CORPORATE RESOURCES

Application by RiverOak Strategic Partners to upgrade and reopen Manston Airport

The Examining Authority's first written questions and requests for information (ExQ1)

Please find below Thanet District Council's response to the first written questions of the Examining Authority.

Drawing file: published-documents / TR020002-002393-4.5 - Special Category Land Plan.pdf

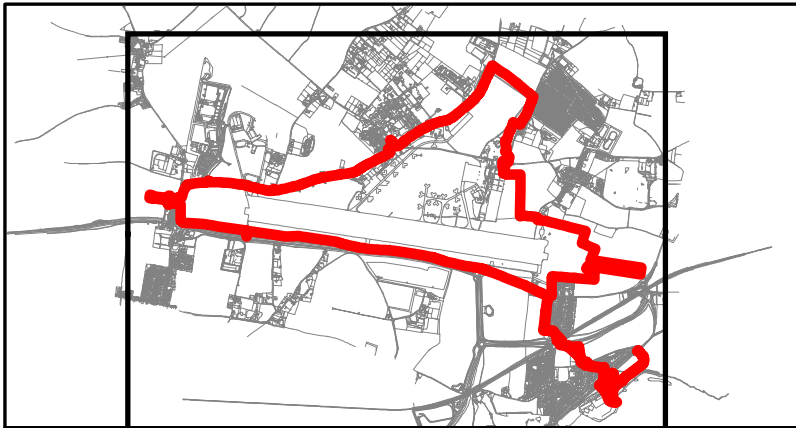
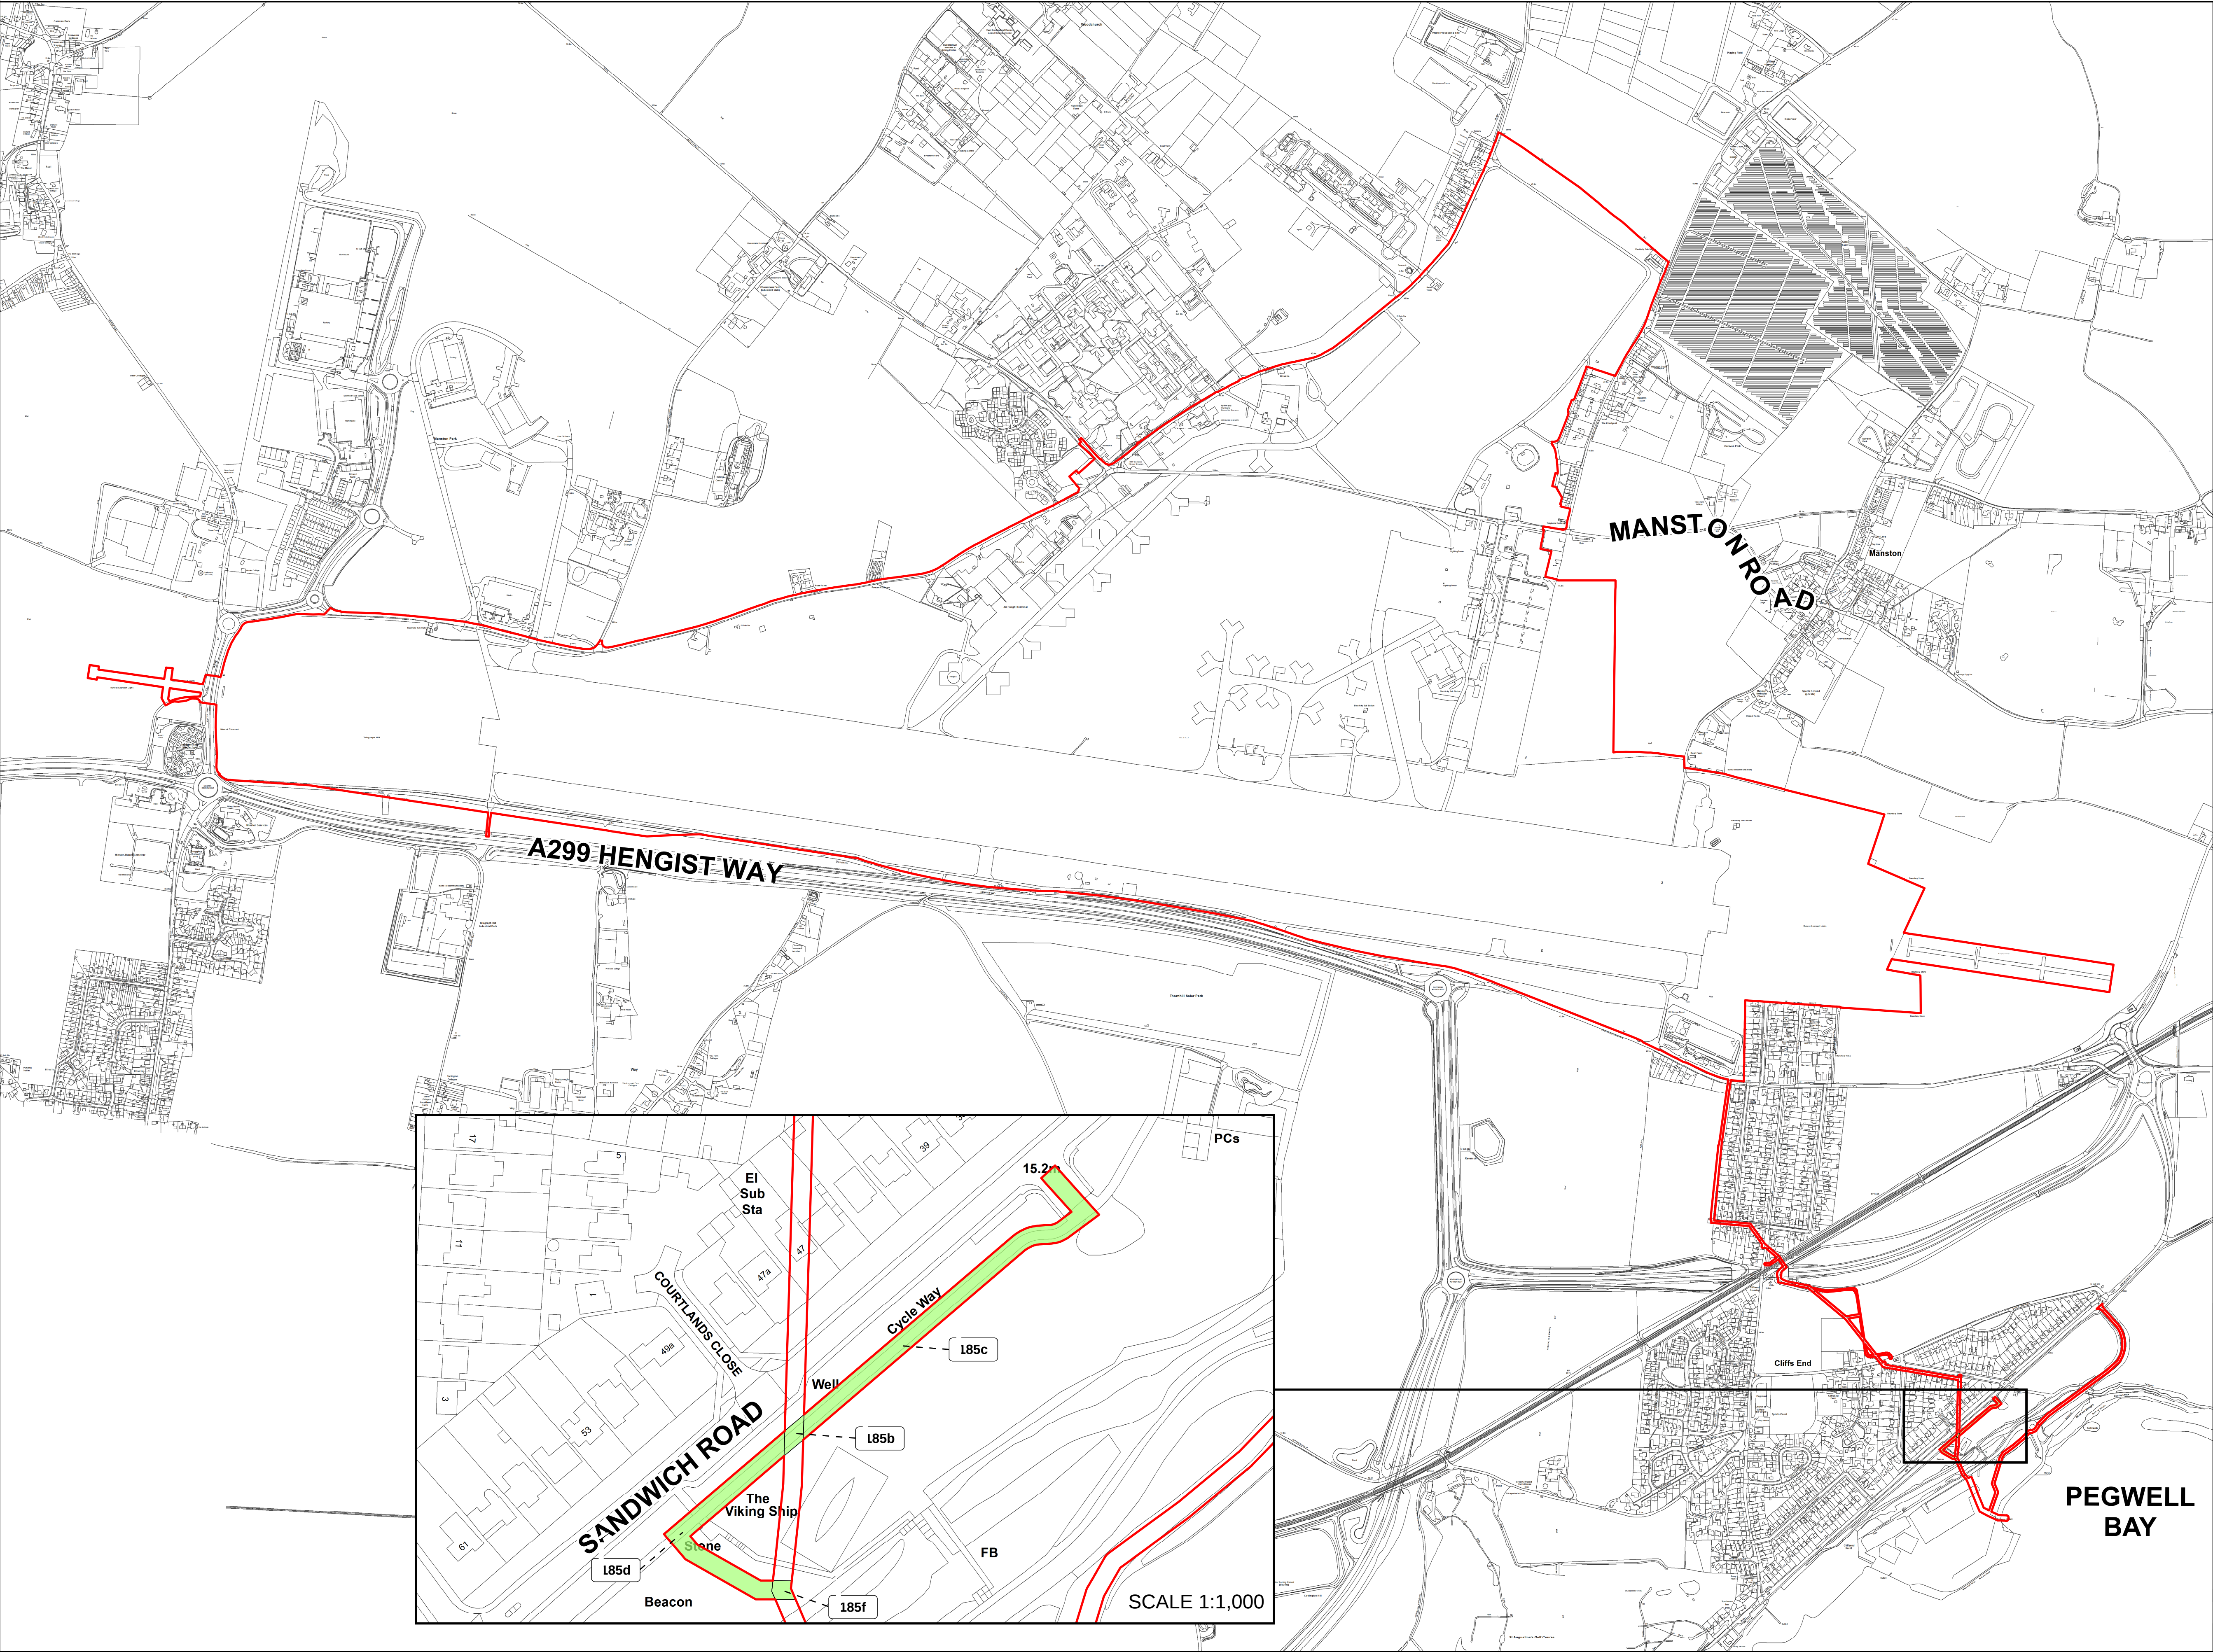
*CA 1.43 PA2008 s132(3) states that this subsection applies if order land, when burdened with the order right, will be no less advantageous than it was before to the persons in whom it is vested, other persons, if any, entitled to rights of common or other rights, and the public. **Set out your reasoned opinion as to whether this subsection is fulfilled in the case of the Special Category Land at plots 185b, 185c, 185d, 185f.***

Thanet District Council considers that the Special Category Land at plots 185b, 185c, 185d, 185f will be no less advantageous to either the Council or the public, given that it will remain as public open space/cycleway available for use by the public and for maintenance by the Council where appropriate.
